The Springs at Steele Creek

Rezoning Petition #95-30(c)
Charlotte, NC

CHARLOTTE-MECKLENBURG PLANNING COMMISSION
INTER-OFFICE COMMUNICATION

DATE: February 23, 2000
TO: Robert Brandon, Zoning Administrator
FROM: Martin R. Cramton, Jr., Planning Director
SUBJECT: Administrative Approval for Petition No. 95-30(c) by Charter Properties, Inc.

# Technical Data Sheet

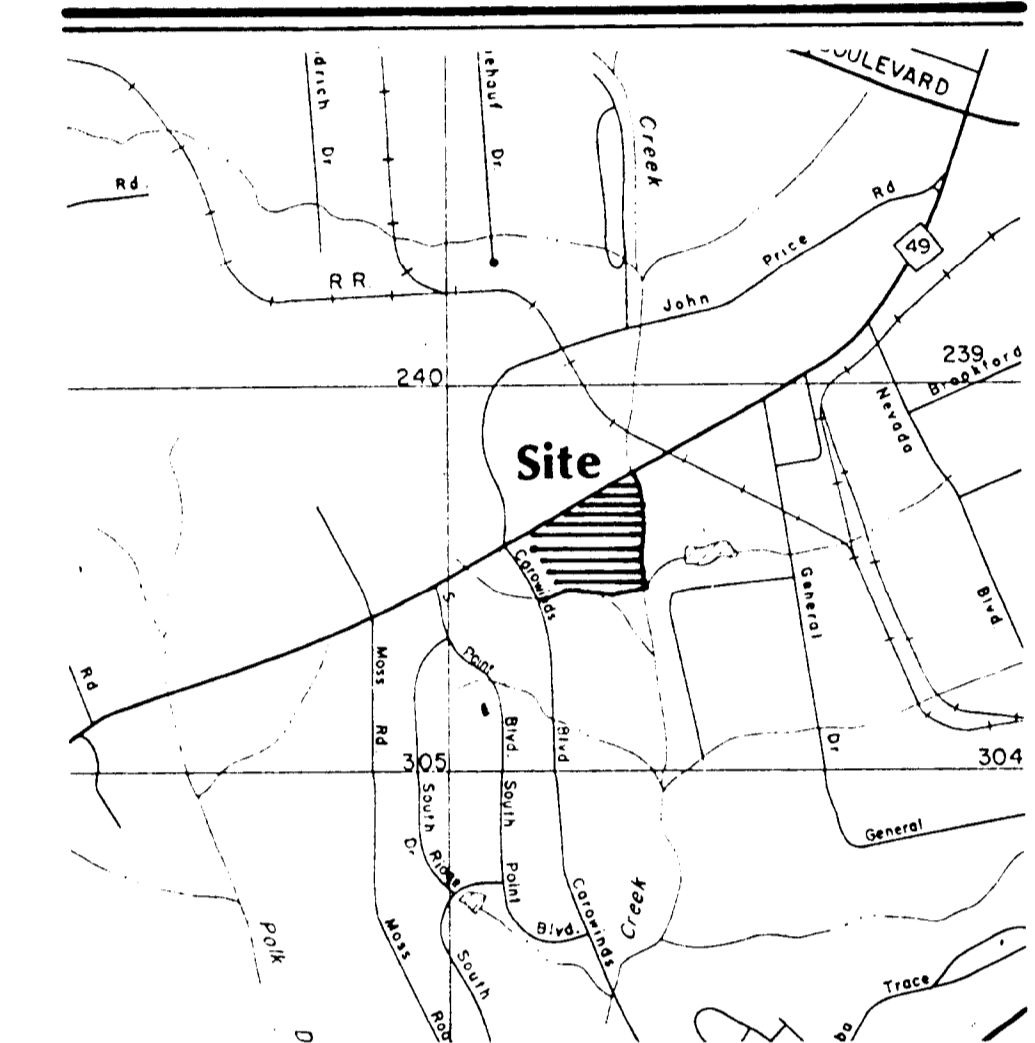
Attached is a copy of the revised plan for the above rezoning petition. The plan has been revised to reduce the setback on the northeast portion of the site along York Road. The NCDOT has requested this additional right-of-way as part of the NC 49 improvements. Since this change does not alter the intent of the development and is minor, I am administratively approving this revised plan. Please use this revised plan when evaluating requests for building permits and certificates of occupancy.
